**Our ref:** LT/2020/125045/01-L01  
**Your ref:** A38 NSIP  
**Date:** 21 February 2020

**ISSUE SPECIFIC HEARING 3 AND 4 ON THE 18TH AND 19TH FEBRUARY 2020 - ENVIRONMENT AGENCY RESPONSE A38 DERBY JUNCTIONS**

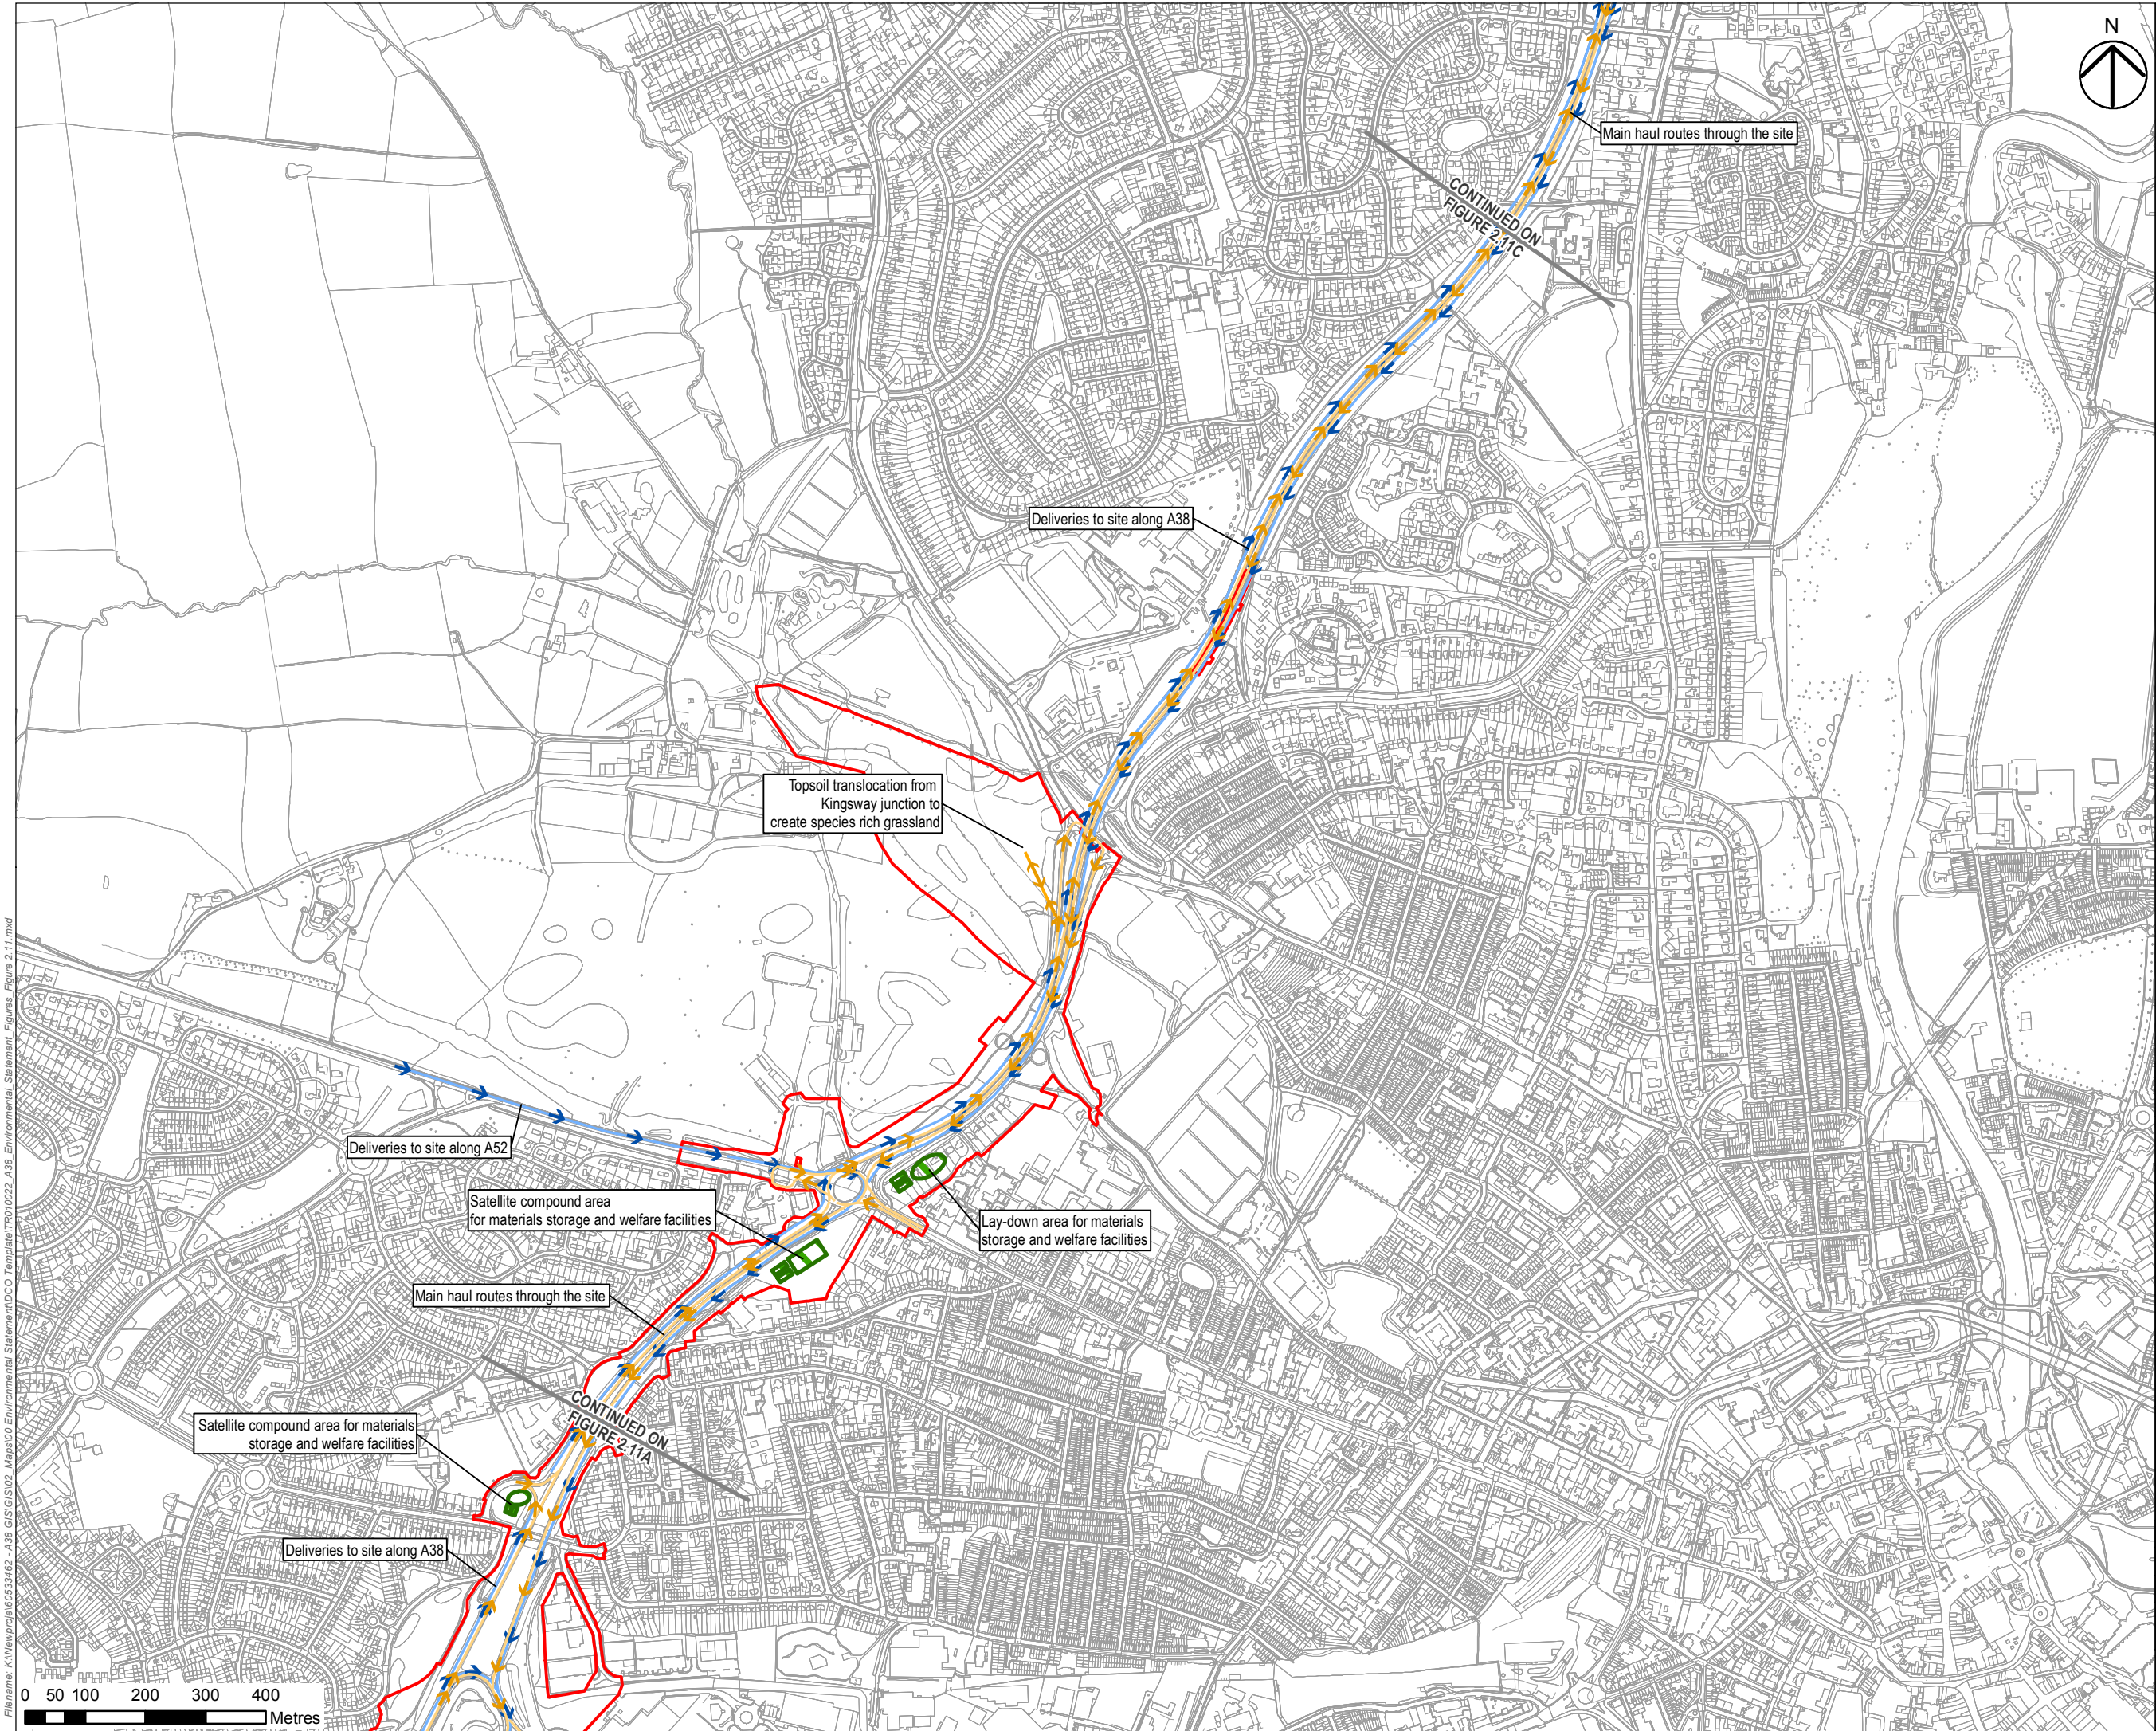
Q23) Preliminary Works - PW-WAT1 refers pollutions risks during weather events and construction and by inference drainage. In our response to a previous Inspector Question on the subject of drainage solutions in the main compound area, we stated that given the sensitivity of this location, details of the drainage solution and pollution prevention measures should be included within the Preliminary Works CEMP. We believe these matters should fall under PW-WAT1. After discussions in ISH4 on this matter we now understand that the details of drainage solutions and pollution prevention

**Little Eaton Construction Compound** – As discussed in the hearing we now understand that the protection of controlled water will be detailed within the Preliminary Works CEMP which we would support.

measures will now be included within the Preliminary Works CEMP.
